ASSESSMENT REPORT

METHODIST LADIES COLLEGE - SENIOR SCHOOL CENTRE SSD 6484 MOD 1

ELEVATIONS - MAIN
 BUILDING

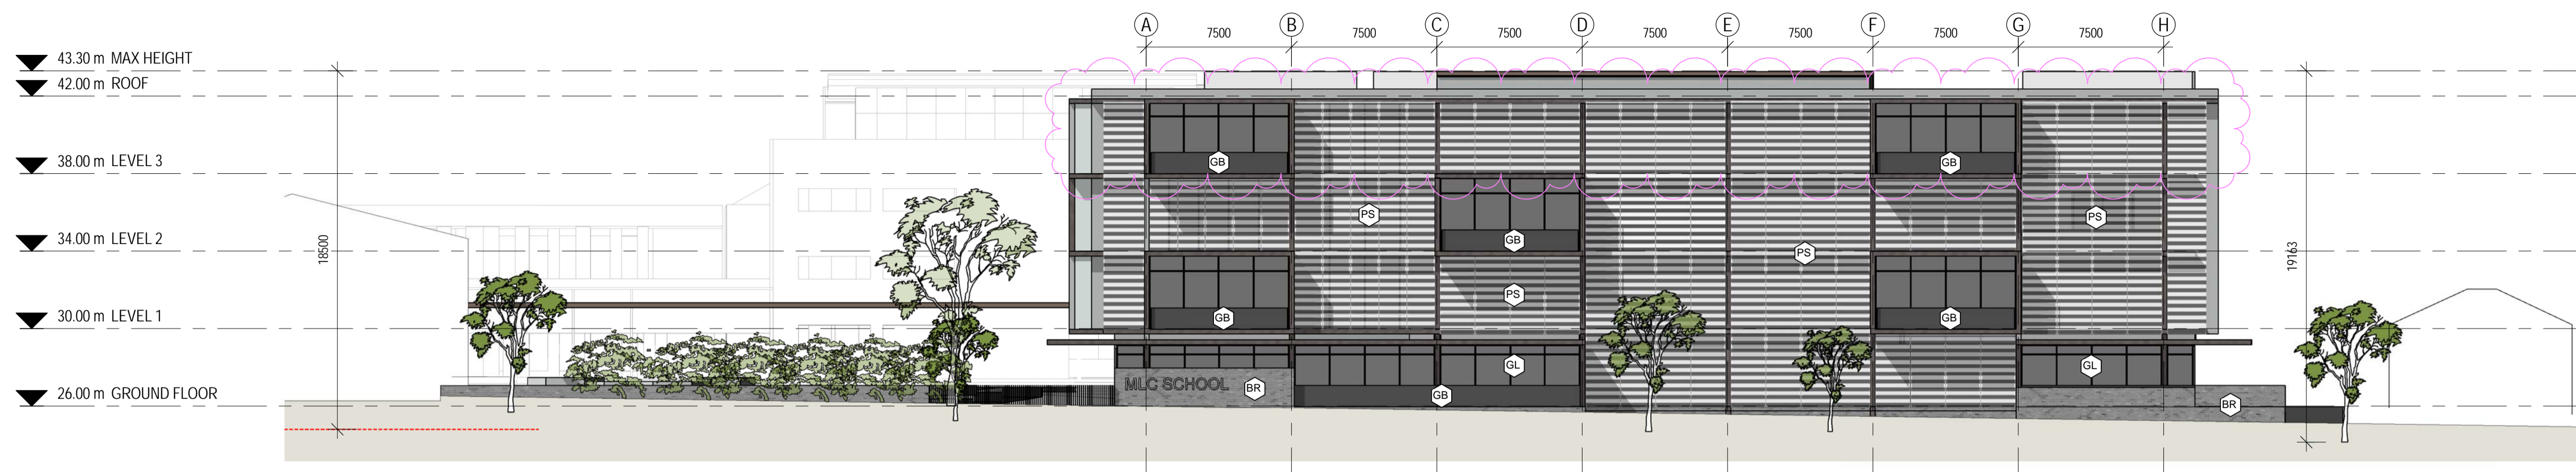
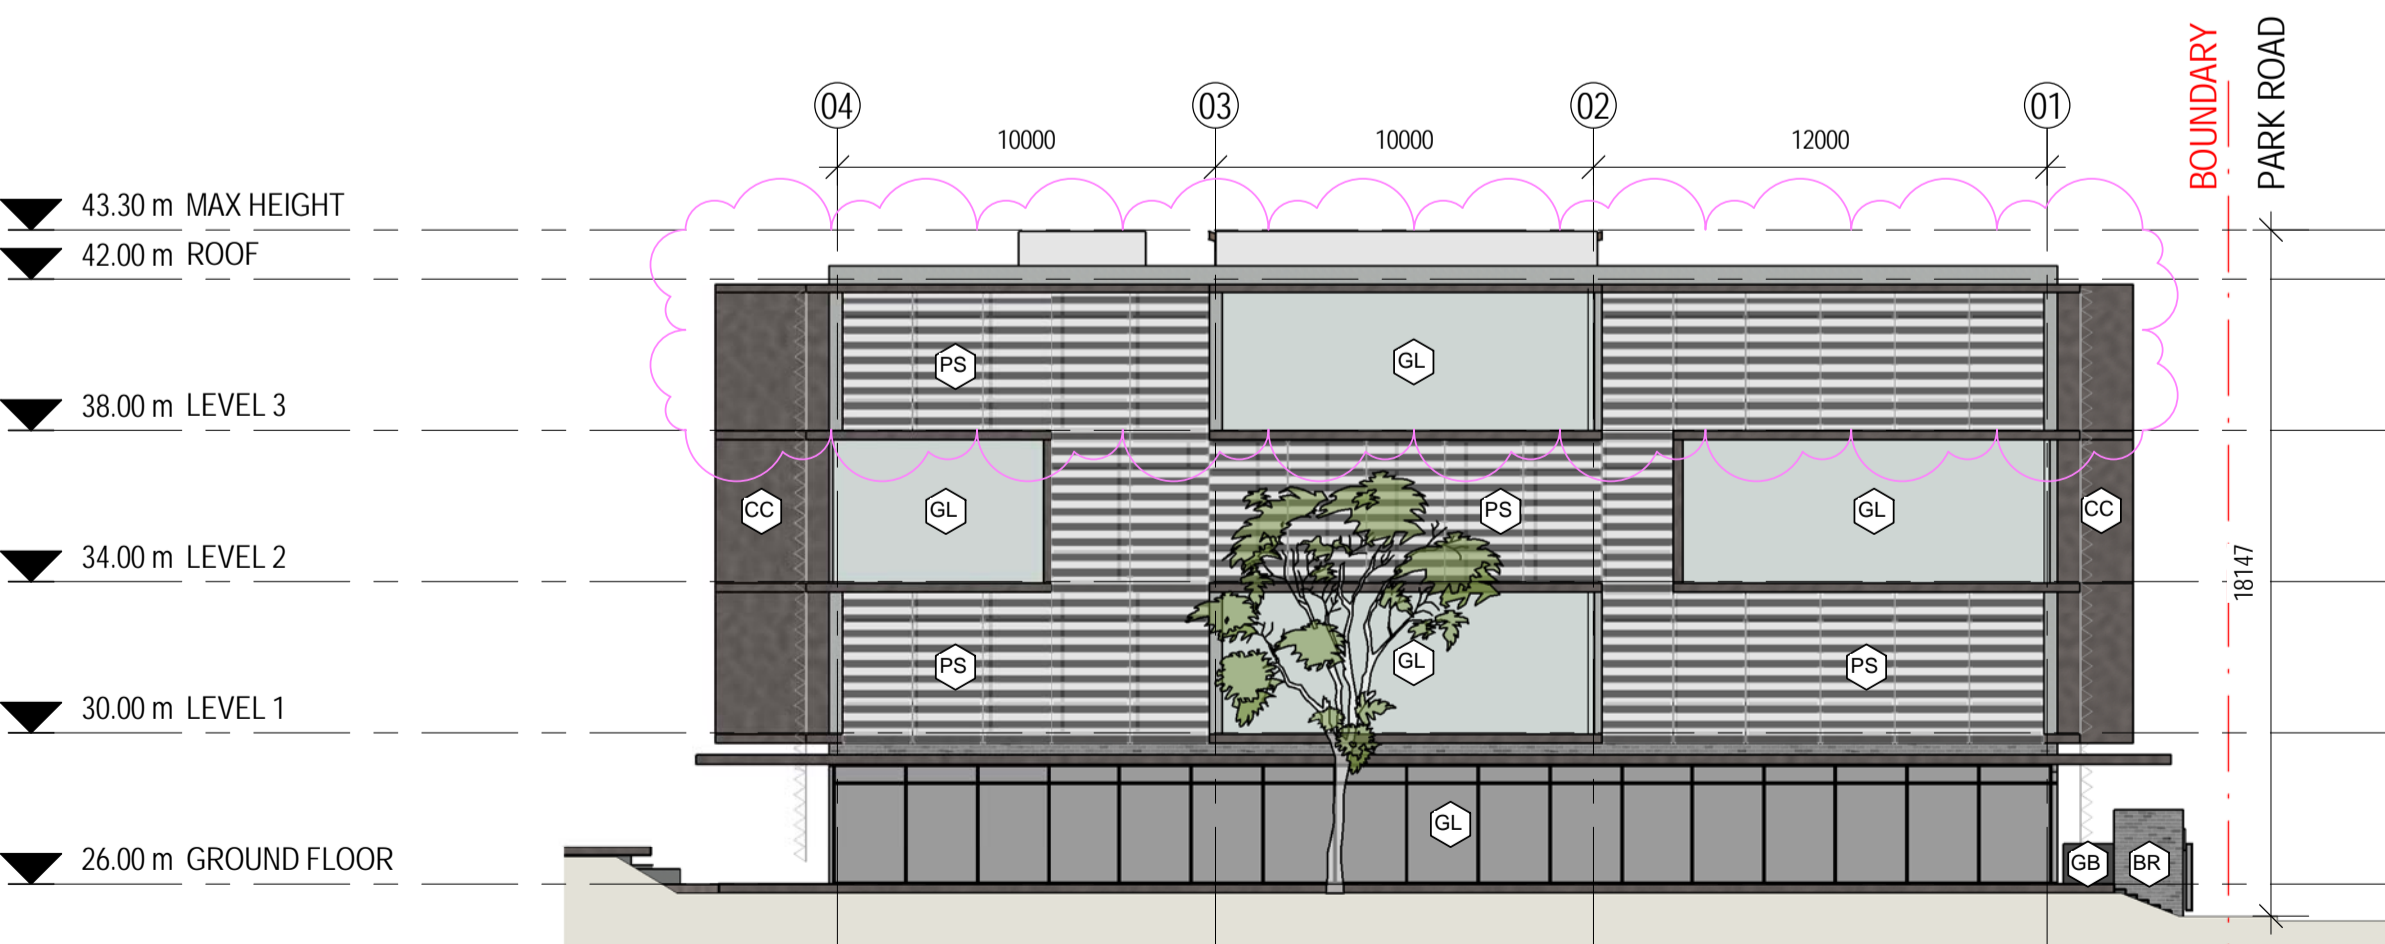
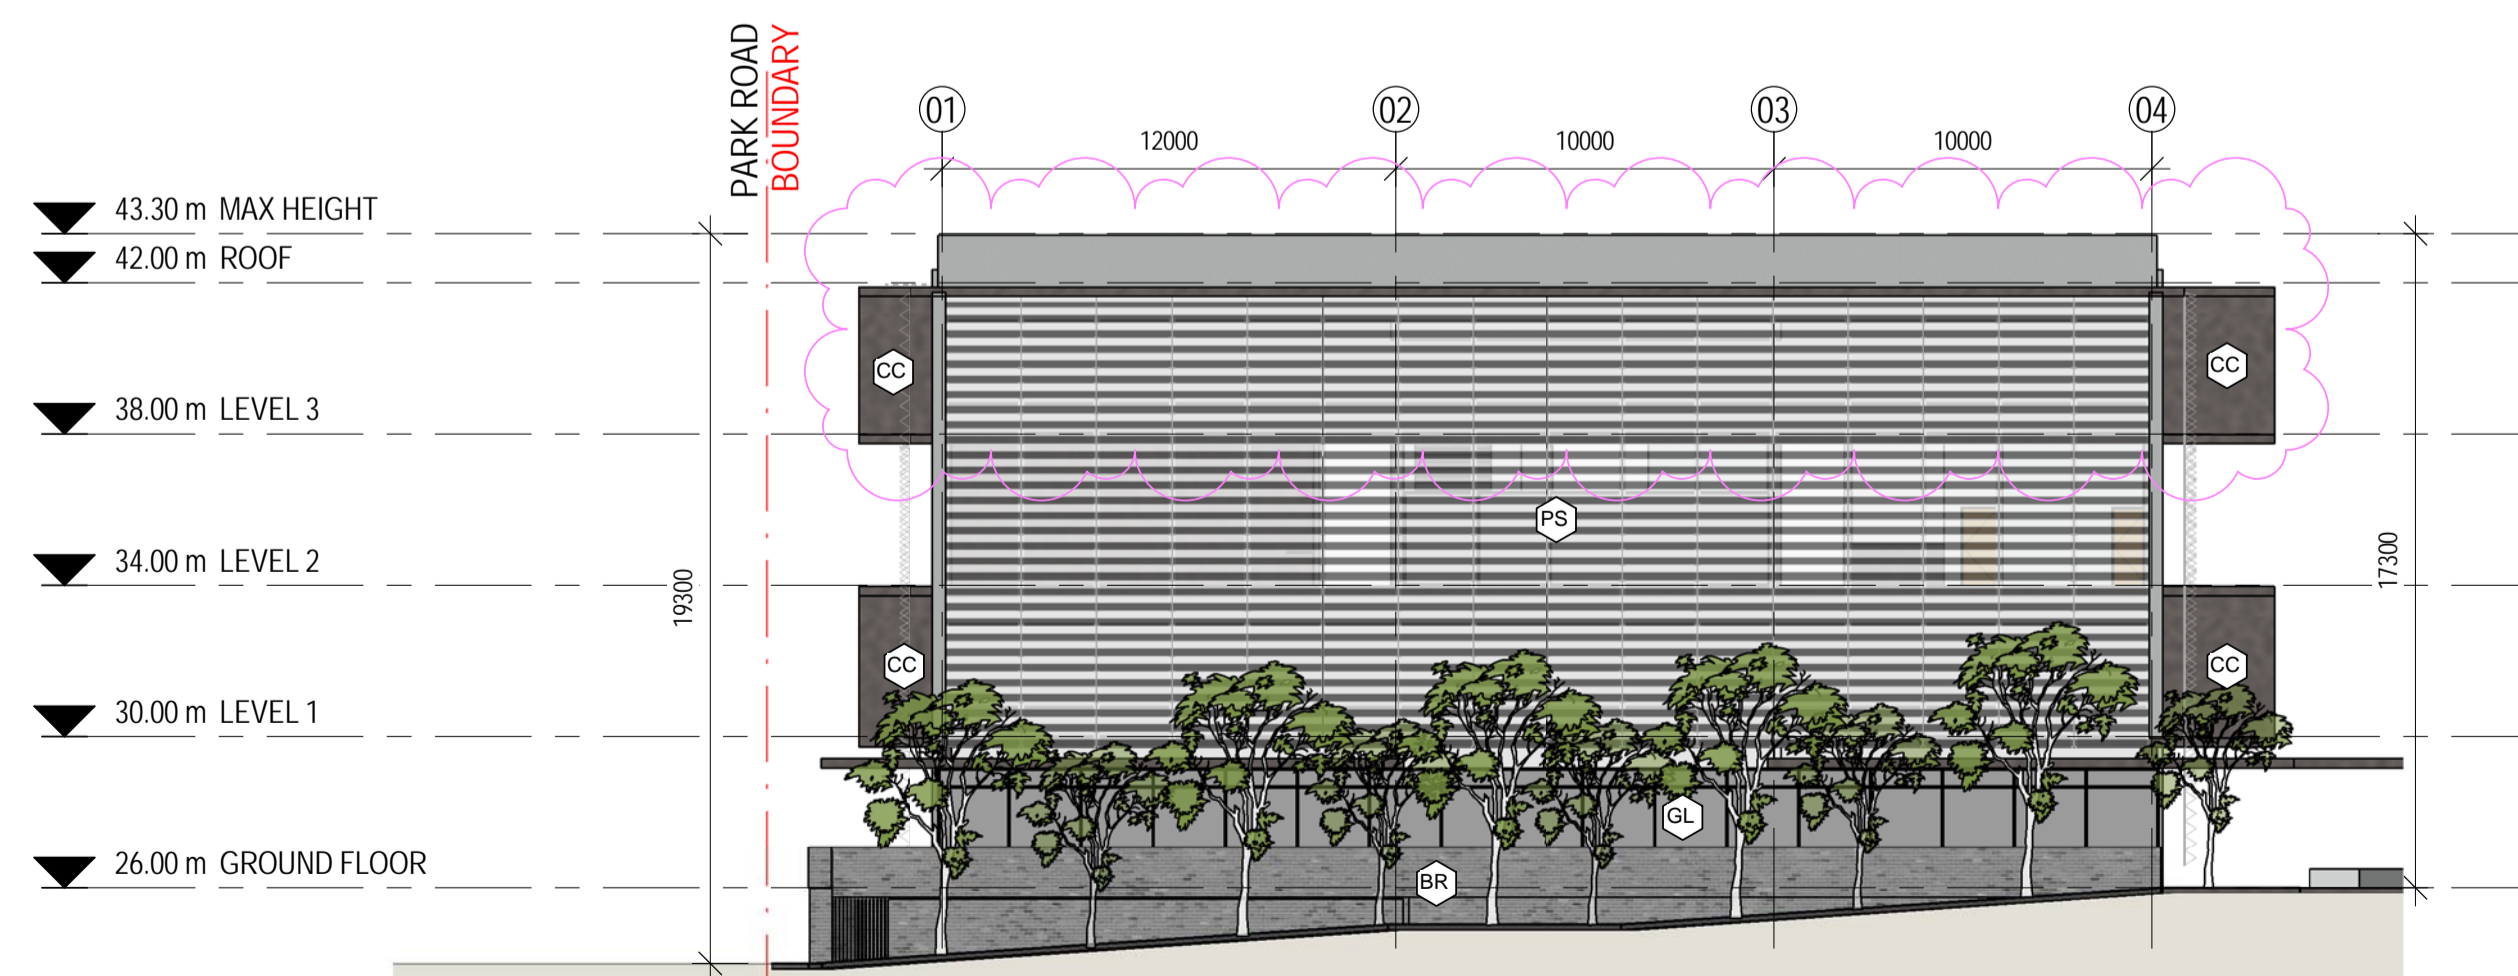
The proposed modification seeks approval to increase the height of the Main Building from three to four storeys or by 3.9 metres (from 14.6 metres to 18.5 metres). The proposal also seeks approval to increase the approved GFA of the Main Building by 862 m² (from 11,462 m² to 12,324 m²).

The Applicant argues the proposed height of the Main Building (Reduced Level (RL) 43.3 metres) is acceptable as it would remain consistent with the height of the tallest existing building on the campus, being the Independent Learning Centre (circled in **Figure 4**). The Applicant also argues the R2 low density residential zoning is inappropriate for the school site, and therefore the development standards associated with that zone are unreasonable.

The Department has undertaken a merit assessment of the potential visual impacts associated with the proposal and considers the additional storey is acceptable as:

- school buildings with greater height and scale relative to the adjoining low scale residential uses have long existed on the site;
- the proposal would remain compatible with the scale and character of the existing and approved school buildings on the site;
- the height of the Main Building would be consistent in height with the tallest building on the site;

- the proposal continues to incorporate a combination of contemporary materials, finishes and architectural features consistent with the original approval which would result in an acceptable design outcome for the site; and
- the six metre landscaped setback along the northern boundary would be retained, providing an appropriate transition to the adjoining residential dwellings.

- the proposal would not result in any additional overshadowing impacts to neighbouring residential properties given the orientation of the site;
- the additional storey would not result in any material privacy impacts, as privacy screens on the northern facade would prevent overlooking of neighbouring properties;
- the proposal would not intensify the use of the school as the number of teachers and students would remain the same;
- car parking demand and traffic generation would remain unchanged; and
- the modified proposal would not result in any new noise sources compared to the approved development.
